right side / west elevation

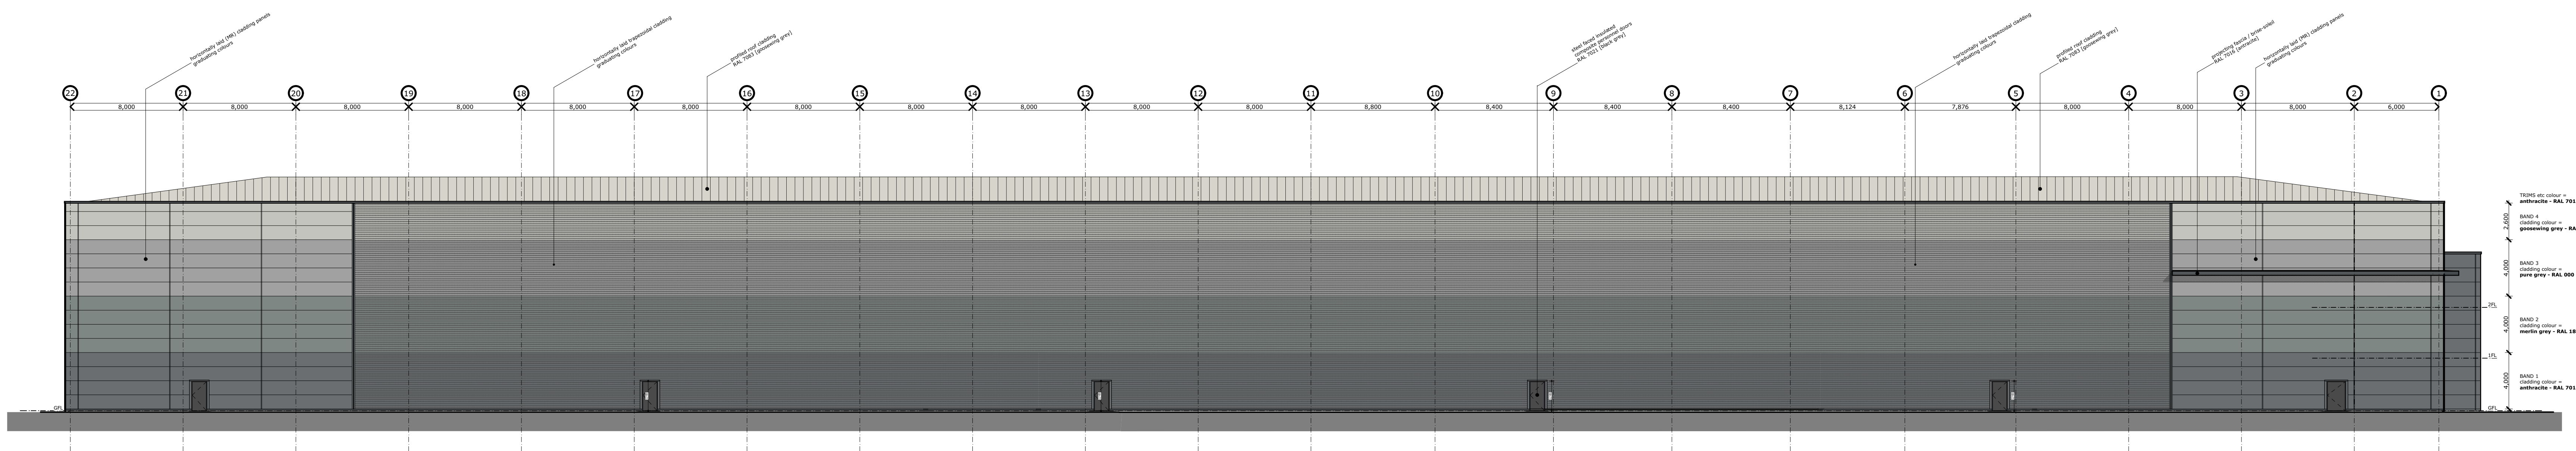
The elevations do not appear to show that the warehouses will be in keeping with the two already constructed, particularly the windows on the west elevation
